**WEST SUSSEX COUNTY COUNCIL
STRATEGIC PLANNING CONSULTATION**

SUBJECT: A/134/13

Outline application for demolition of Broadlees and erection of up to 27 x 2-bed age restricted cottages, a 60 bed care home, laundry room, managers cottage and guest suite, and a core care block comprising up to 60 nursing beds with associated car parking - This is a Departure from the Development Plan.

Land at Broadlees, Dappers Lane, Angmering, West Sussex, BN16 4EN

Proposed Site Plan

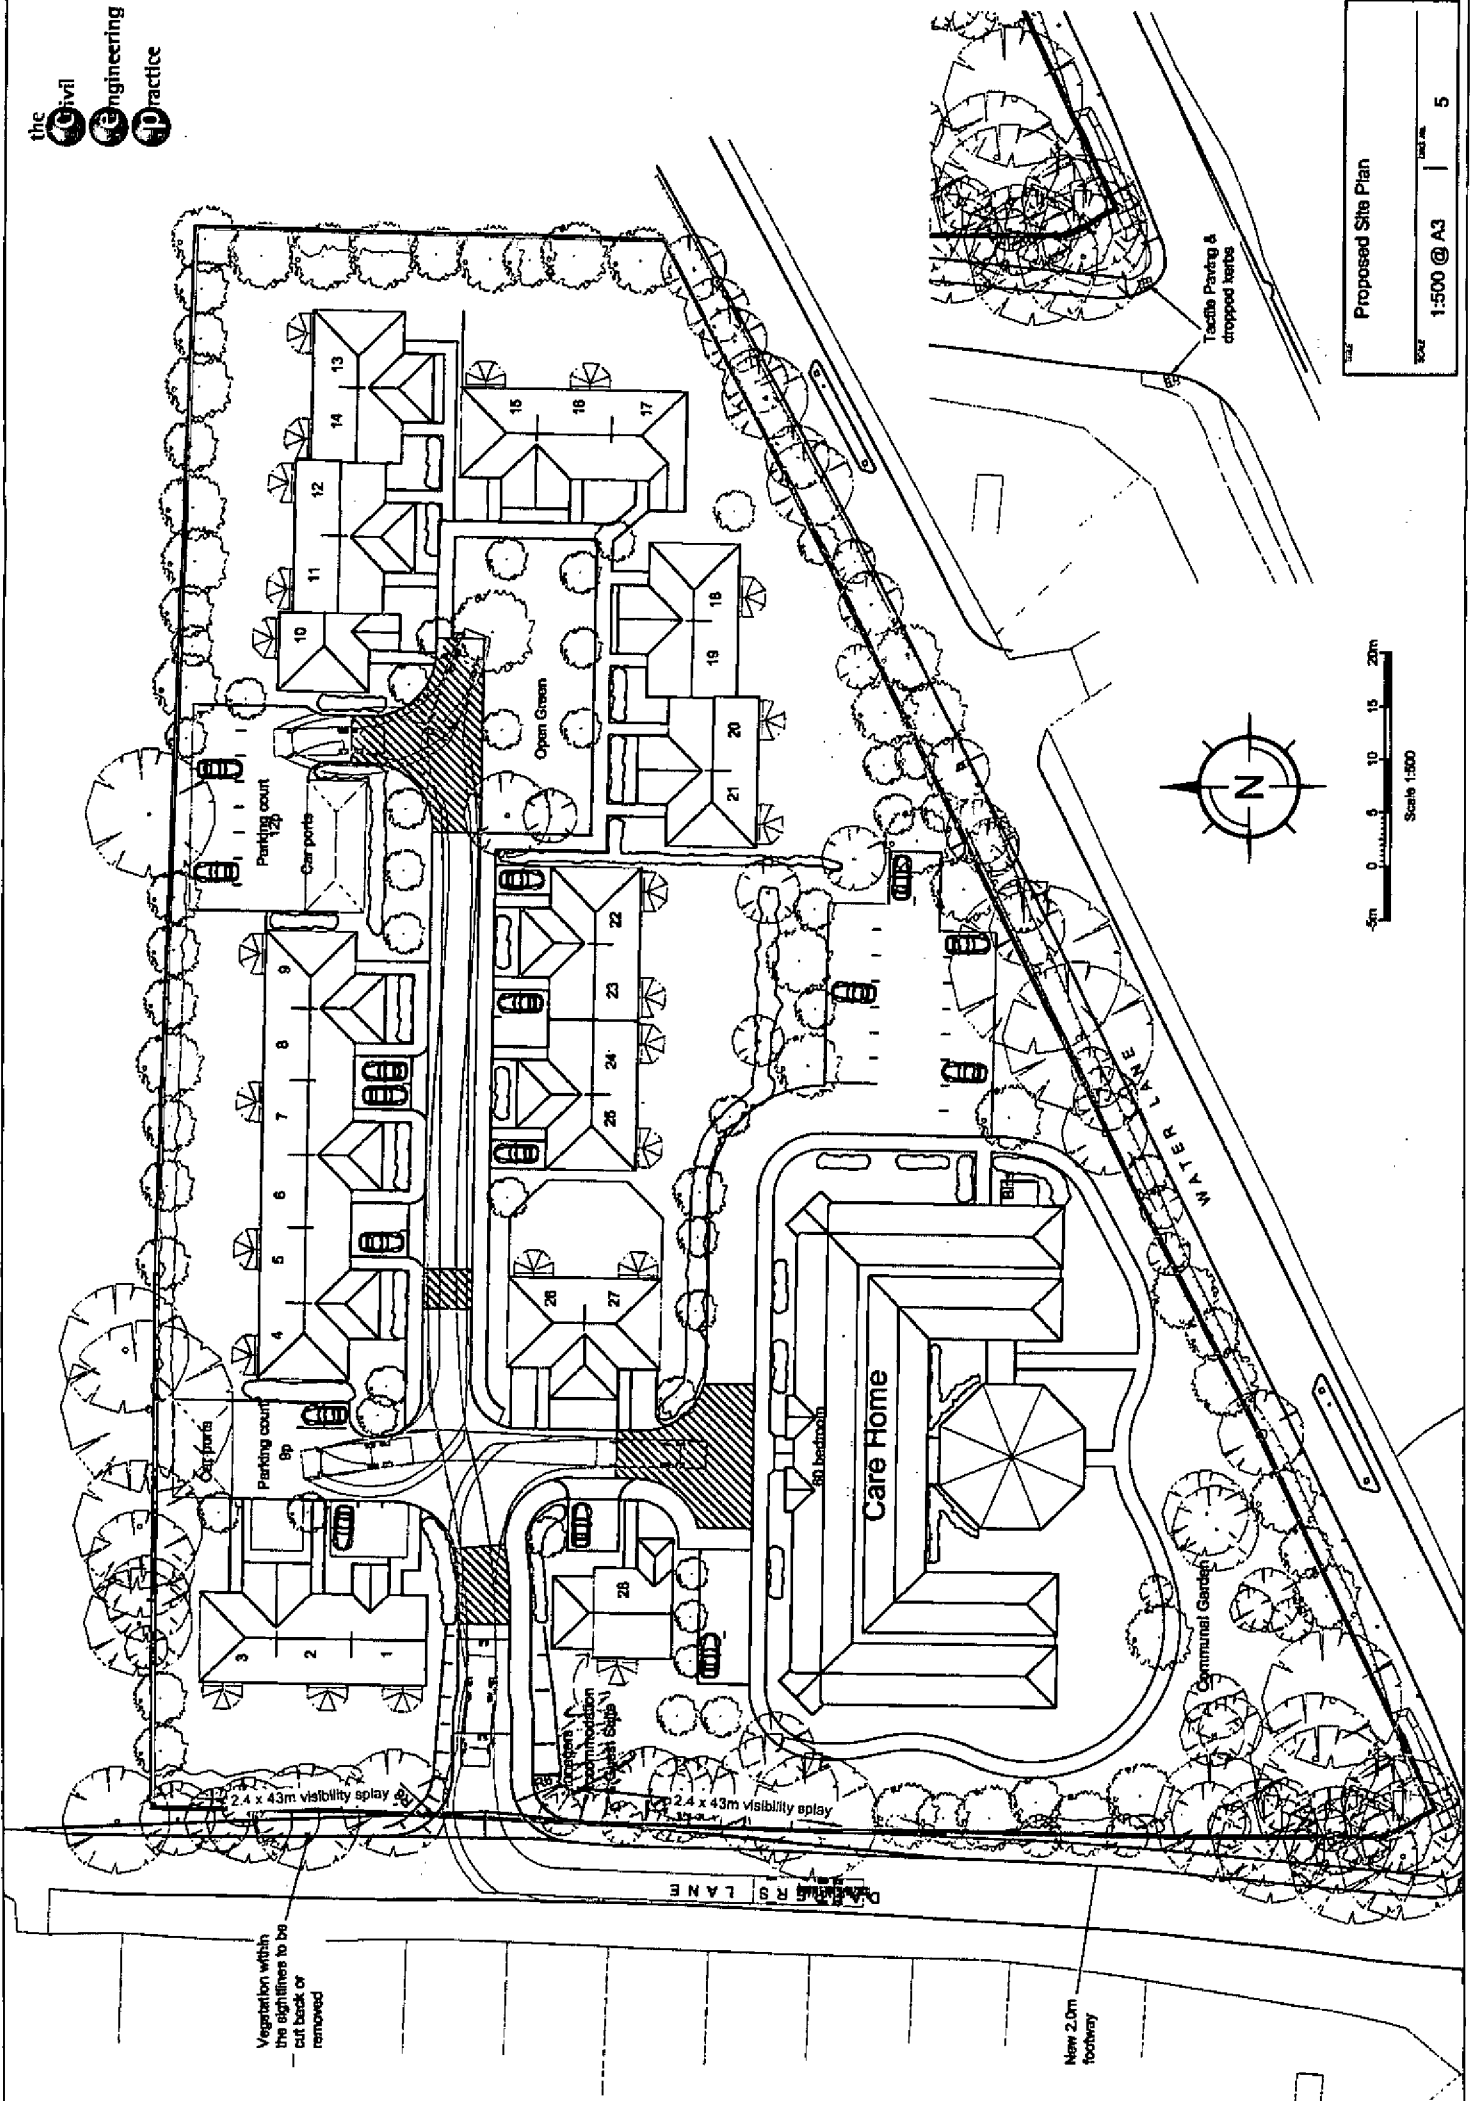
A provision of 19 spaces has been allocated to the care home; the WSCC Parking Standards indicate a maximum allowance of 0.5 spaces per unit plus staff space. No evidence has been provided to indicate whether the provision will be adequate to serve the needs of the development. Given the access road to the care home is not required to manoeuvre a refuse or large vehicle it is unlikely that this would have an impact on access, however, an under provision could lead to on-carriageway parking within the internal layout. Further consideration should be given to the parking requirement for this element of the development through any subsequent reserved matters application relating to the layout with either evidence to support the provision or additional car parking provision.

A scheme of highway works to provide a 2.0m wide footway extending the sites junction with Dappers Lane to the junction of Dappers Lane/Water Lane, including the provision of a dropped kerb uncontrolled crossing, as shown indicatively in drawing 'Proposed Site Plan: 5'
